16050 Old Denver Road CS Rezone

Date: December 15, 2023
To: Kylie Bagley, Planning and Community Development Department
From: Nancy Prieve, Environmental Division, Parks & Community Services Department
Subject: 16050 Old Denver Road Rezone CS235

# 16050 Old Denver Road CS Rezone

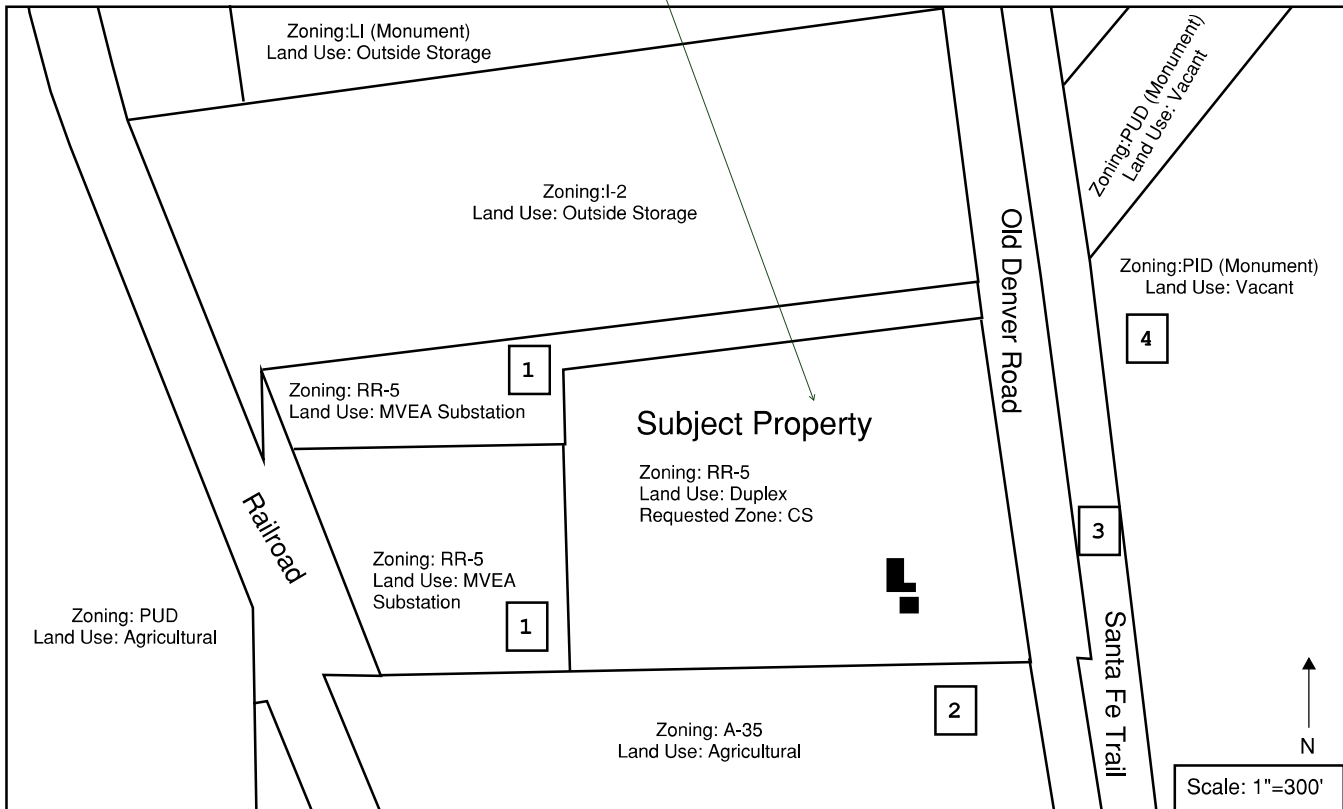
Include parcel size,
property tax schedule
number, property
address and legal
description

RESPONSE: parcel size added,
tax no., property address. the legal
description is below.
